**Consultation Response from KC,
Conservation & Design**

2025/90549 & 2025/90548 78, John William Street, Huddersfield, HD1 1EH

**Listed Building Consent for change of use and alterations to convert offices to 14 apartments
(use class C3) (within a Conservation Area)**

Date Responded: 12/6/2026

LOWER GROUND FLOOR

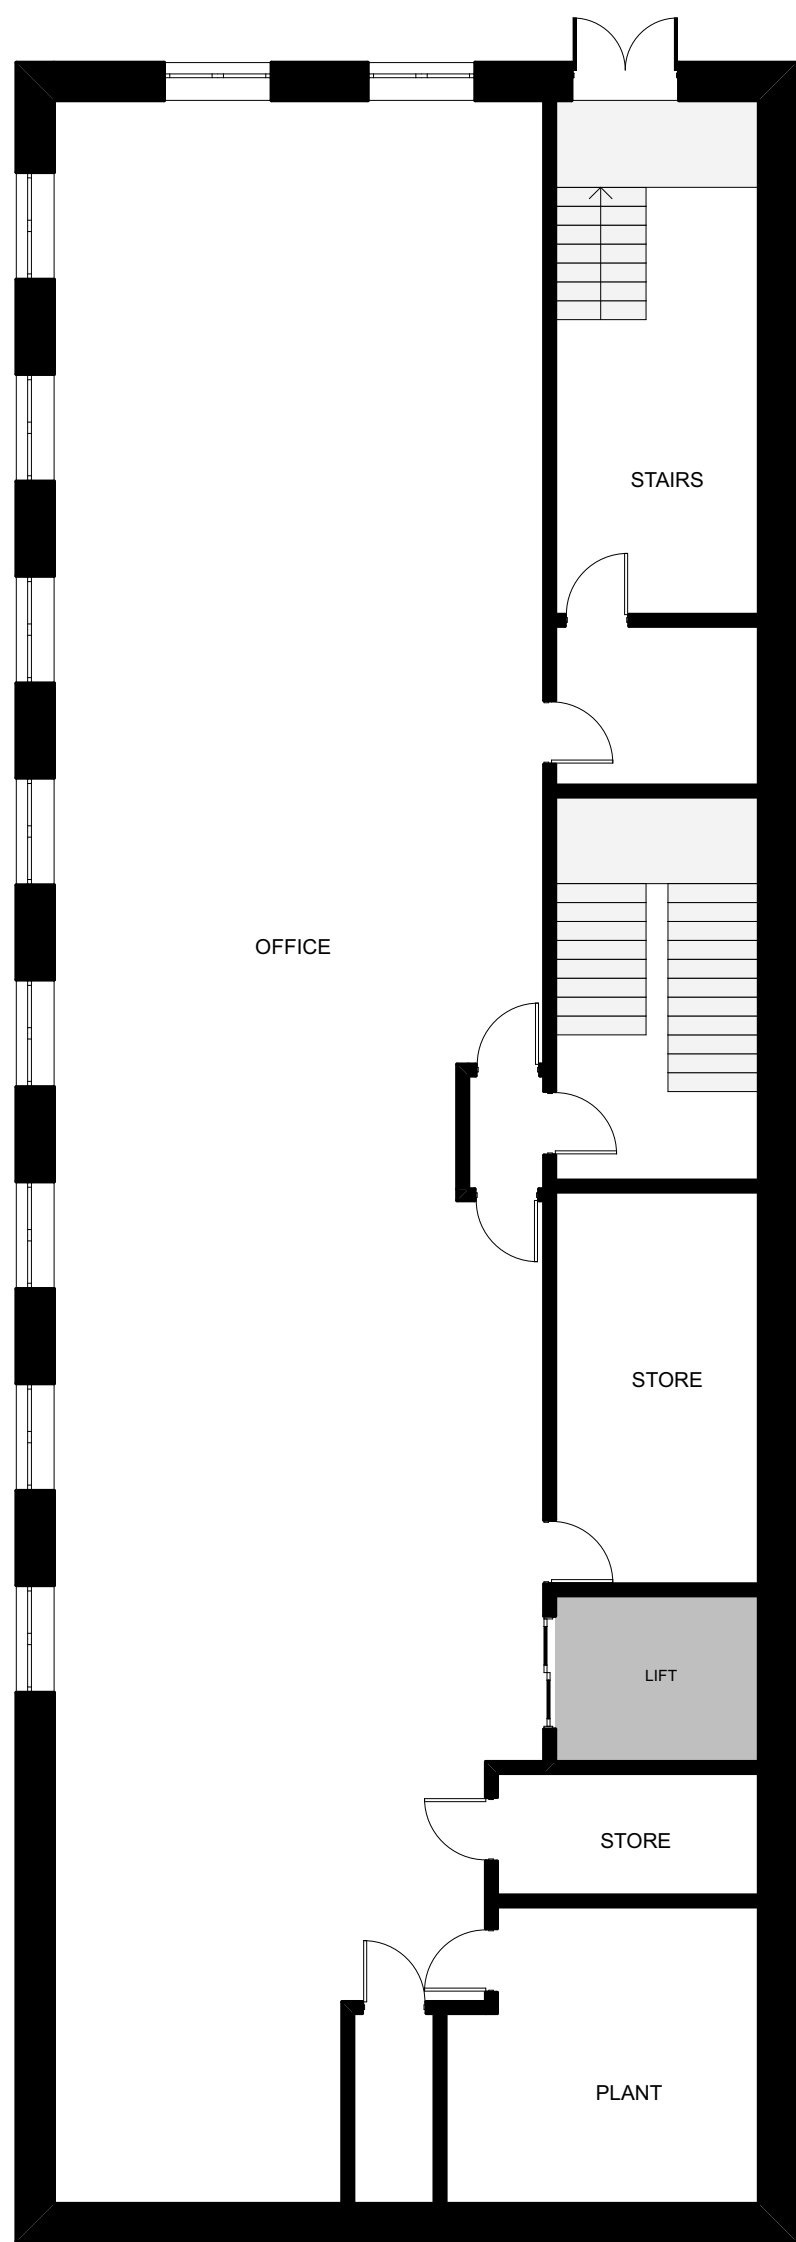
The lower ground floor proposes an alteration for the staircase to move from one side to the other. The other main staircases within the rest of the building would remain. I consider that only the lower ground floor staircase alteration (would not be classed as a principal internal element) would not be classed as a substantial part of the interior, as it is only a small part of the interior, so I consider would not require notification in this case.
